From: Michael Eastham
Sent: 15 January 2019 11:26
To: Laura Gibbons
Cc: Planning.Responses; Paul Cann
Subject: FW: Planning Consultation on BN/59/18/DOC

APPLICATION **BN/59/18/DOC**
NO:

Registered: 11-DEC-18
Site Address: Land at Lake Lane Barnham

Description of Works: Approval of details reserved by condition imposed under ref APP/C/3810/A/13/2193942 relating to Condition No 5 surface water drainage, Condition No 6 SUDS system and Condition No 7 foul drainage.

Title: **Private Drainage Layout Sheet 2 of 3**

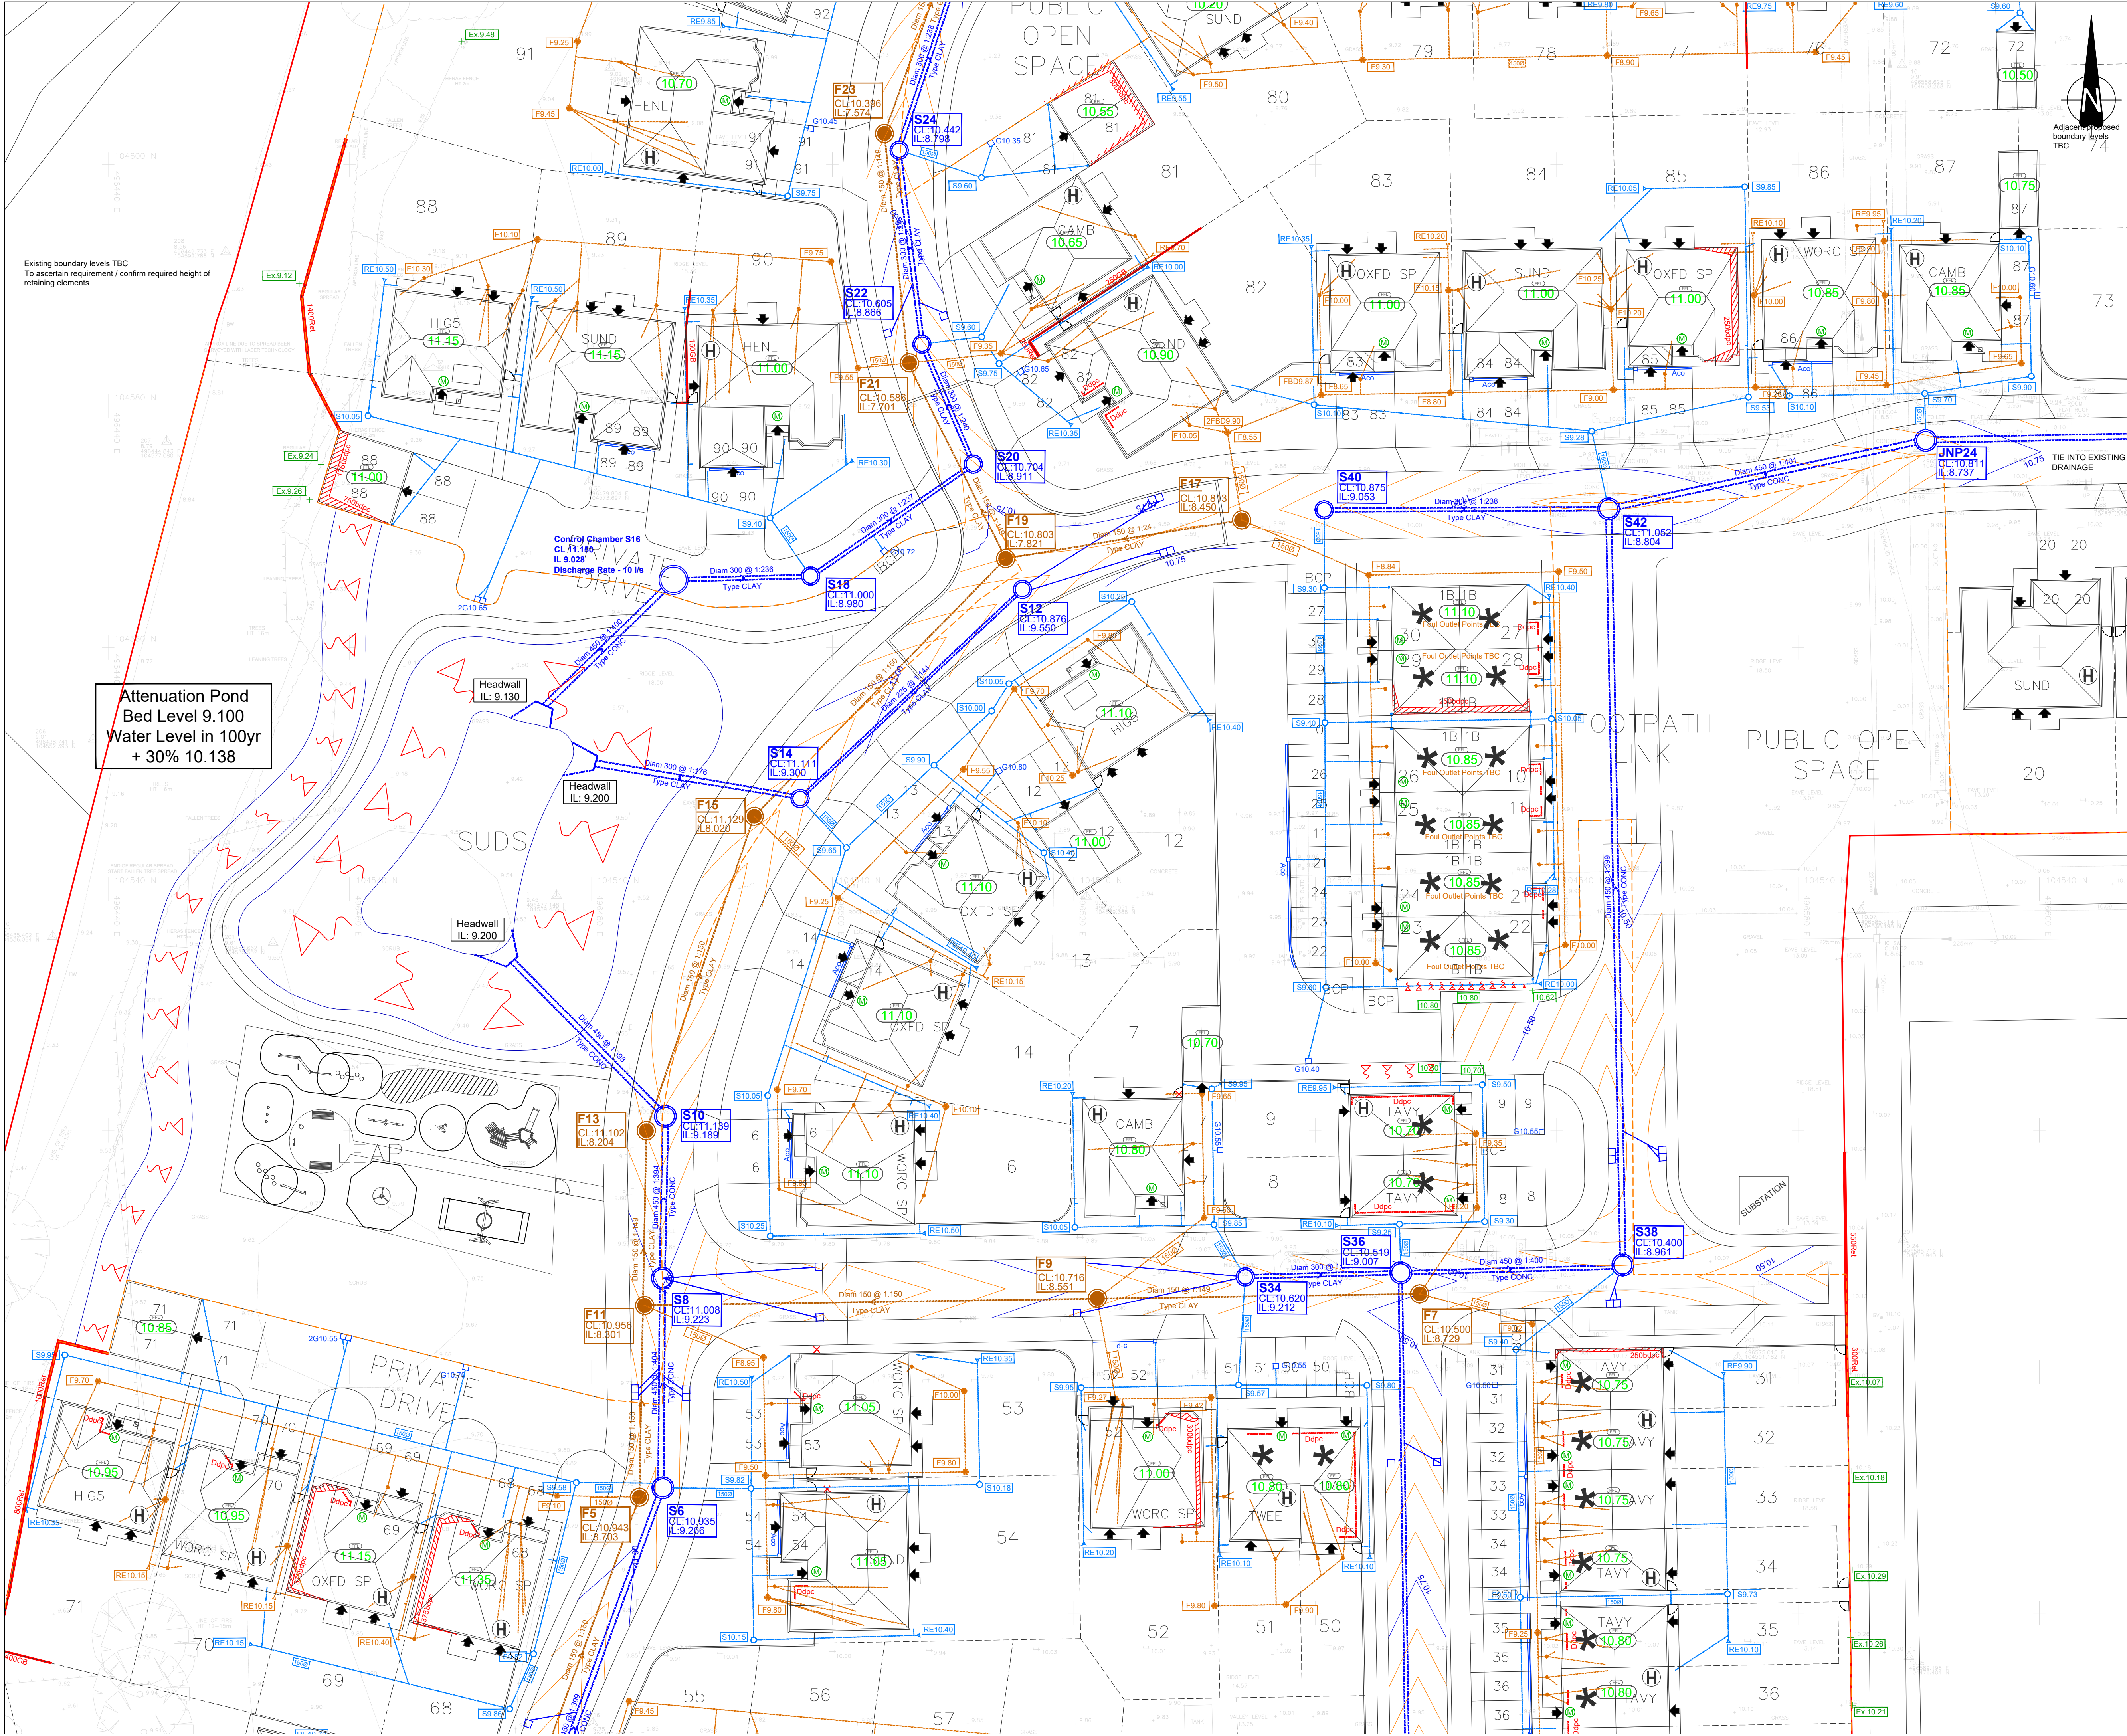
Please can the drainage layout and details drawings, maintenance manual etc. be updated to include the drainage originating from the rear of the retaining walls.

I have been advised by the Redrow Technical Team that the retaining walls have been constructed with weep holes, at regular intervals, which relive the build-up of surface water on the high side of the retaining walls.
